CONSULTEE RESPONSE (Arun District Council - Arboriculturist)

Reference: WA/51/26/RES

Proposal: Approval of reserved matters following the grant of outline planning permission WA/35/23/OUT, for the construction of 95 no. new homes, access, new pedestrian and cycle links, open space, landscaping, habitat creation, drainage features and associated groundworks and infrastructure, including details relating to the Sensitive Lighting Strategy, POS details and Part M Compliance. This application is in CIL Zone 3 and is CIL Liable as new dwellings.

Location: Land East of Wandleys Lane, Fontwell

Based on: 5988-005-5551

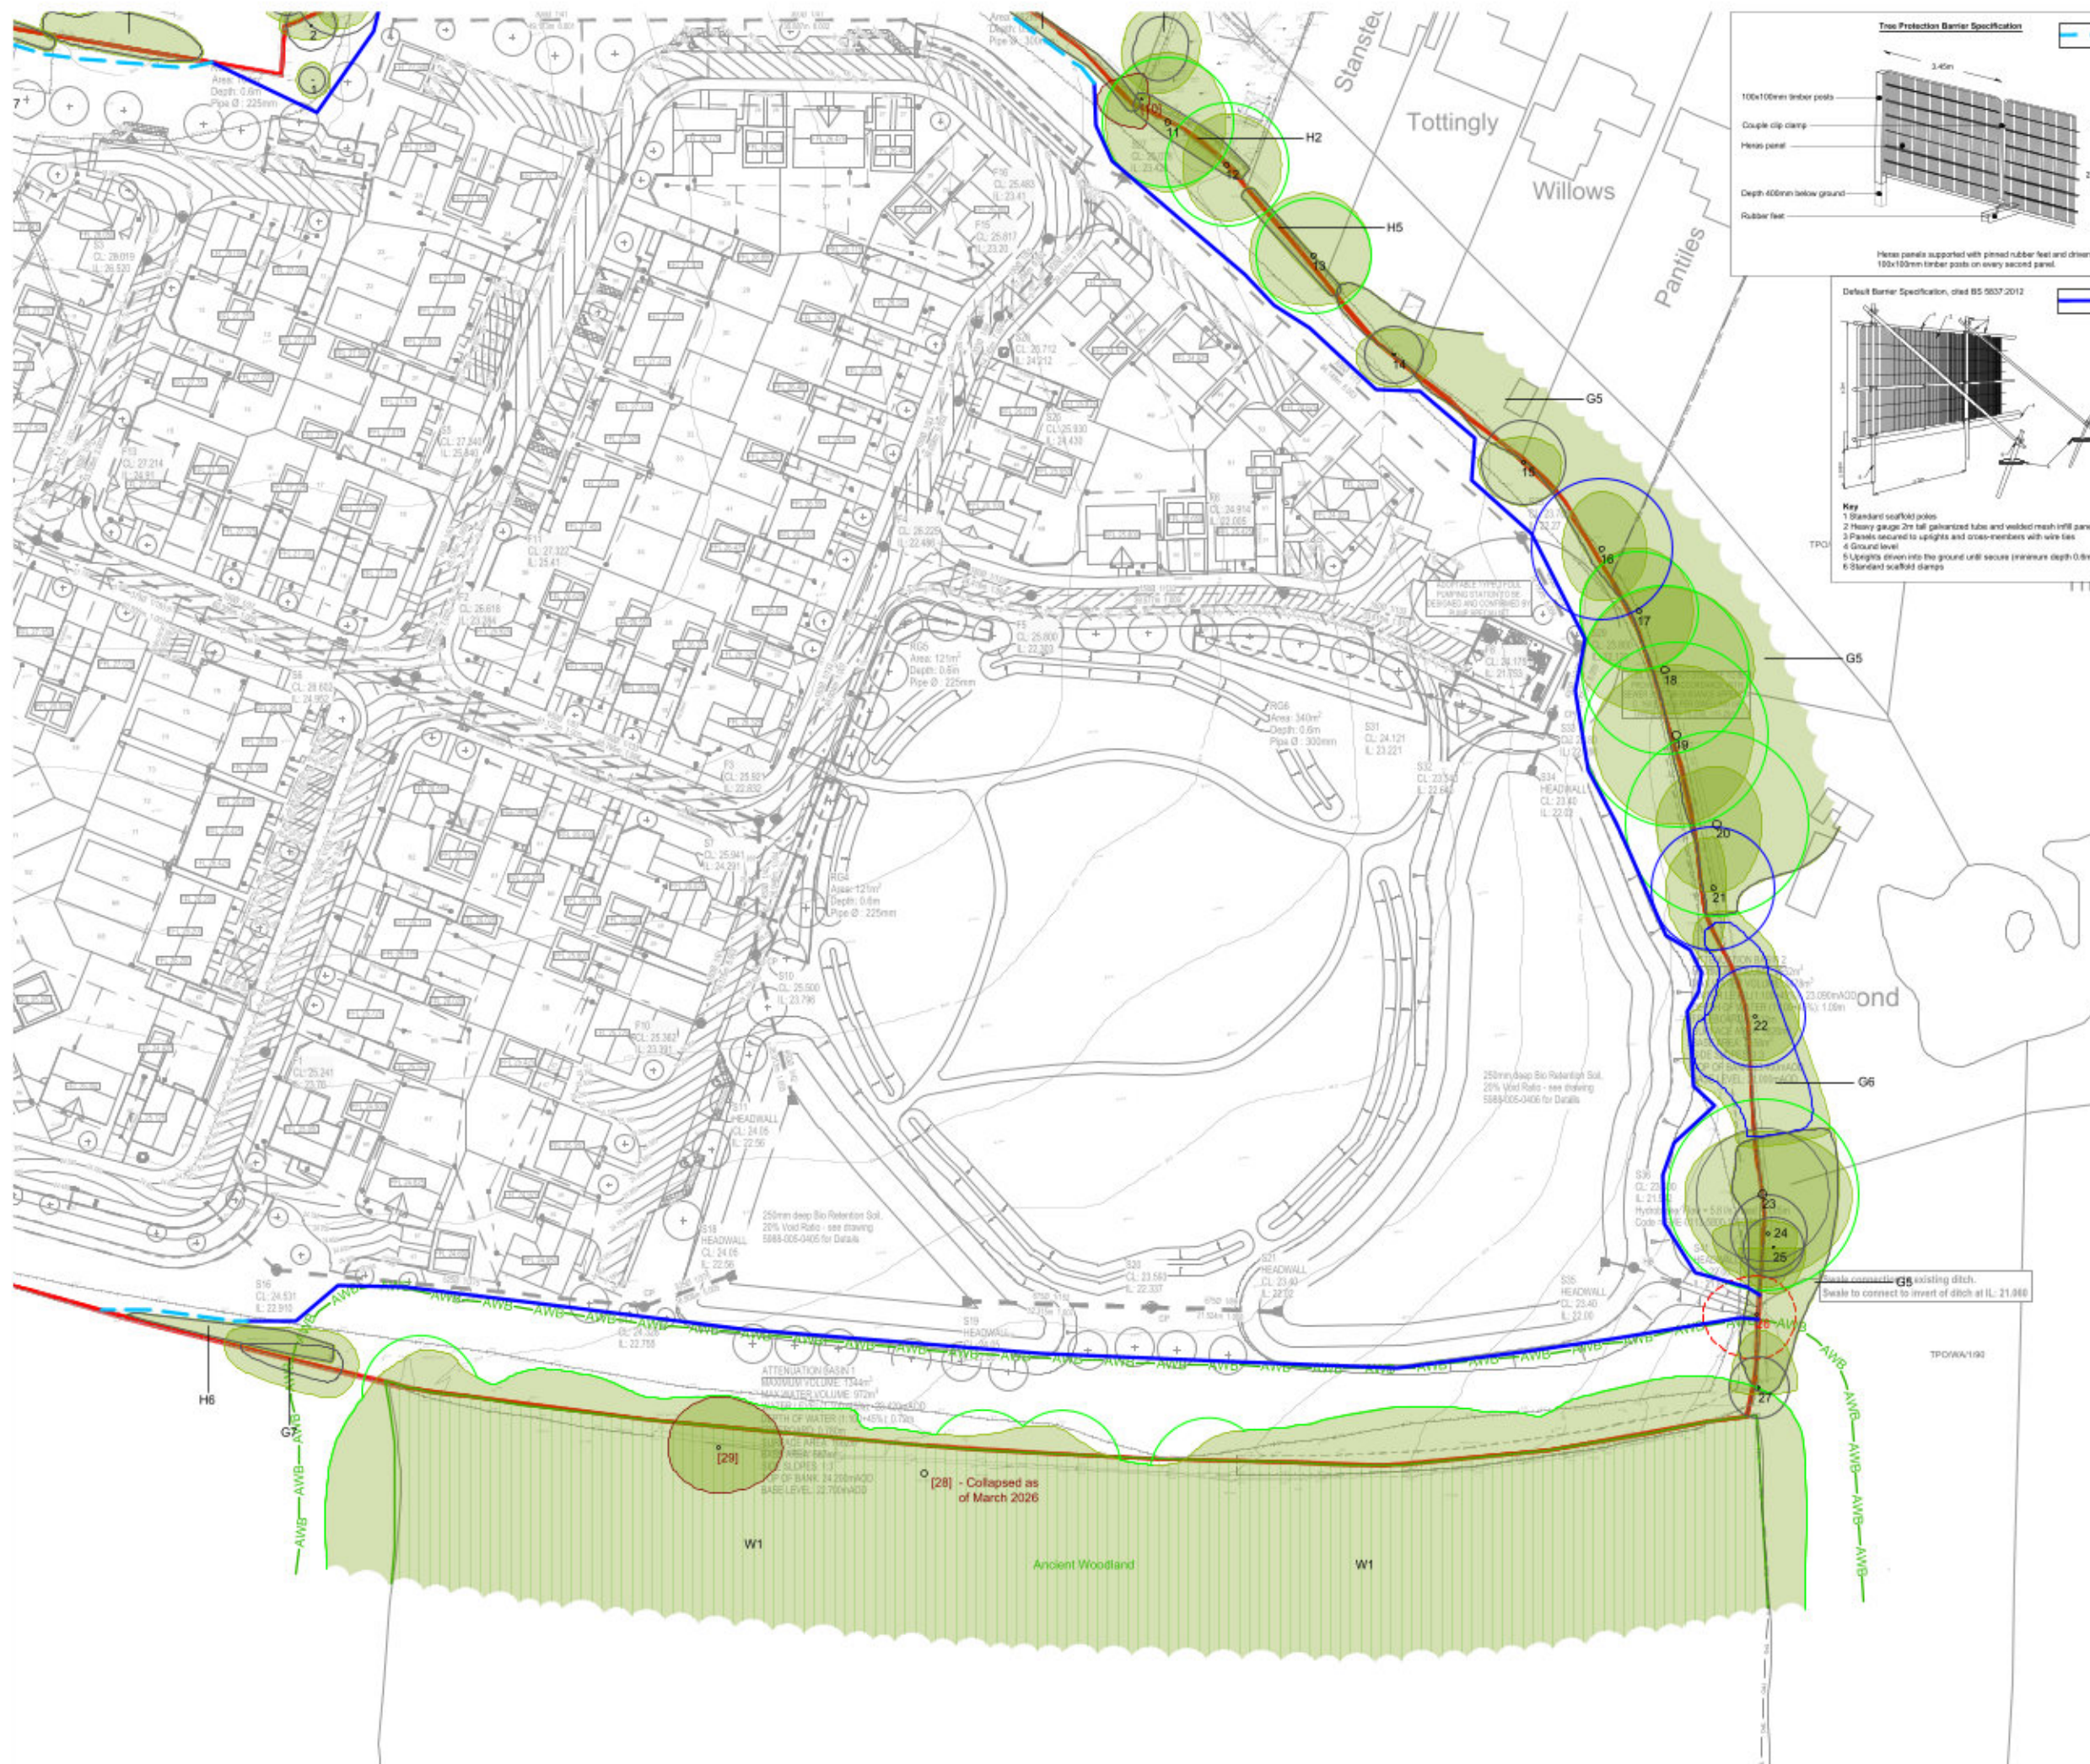
There is no mention in the AMS of TPO/WA/1/24, which affects individual oak trees T18, T19 & T23 (their refs.) and TPO/WA/1/23 a woodland order which affects the whole of Wandleys Copse (ref. W1). Those individuals may be referenced on a TPP but I cannot confirm due to the poor resolution under magnification of the copies available to me.

1. Dwellings, supporting road network and surface water drainage infrastructure is proposed adjacent the AWB. Indeed, both attenuation basins 1 & 2 are partly within.
 2. Changes to the water table or drainage. Drainage Plans suggest the existing exceedance flow across the site is toward the south and east, affecting both habitats and important trees (TPO).
 3. RPA +2m buffer - incursion from construction.
 4. Increasing levels of air and light pollution, noise and vibration
-
5. Increasing disturbance to wildlife, such as noise from additional people and traffic
 6. Increasing the amount of dust, light, water, air and soil pollution
-

A buffer of 2m beyond their calculated RPA should be implemented for trees T11 – T25, if they have not been afforded veteran tree status. This to ensure no construction creep during the creation of attenuation basin 2 and demand a relocation of proposed subterranean utility apparatus to outside of this greater construction exclusion zone (CEZ).

The construction of swales within the AWB is incompatible with guidance.
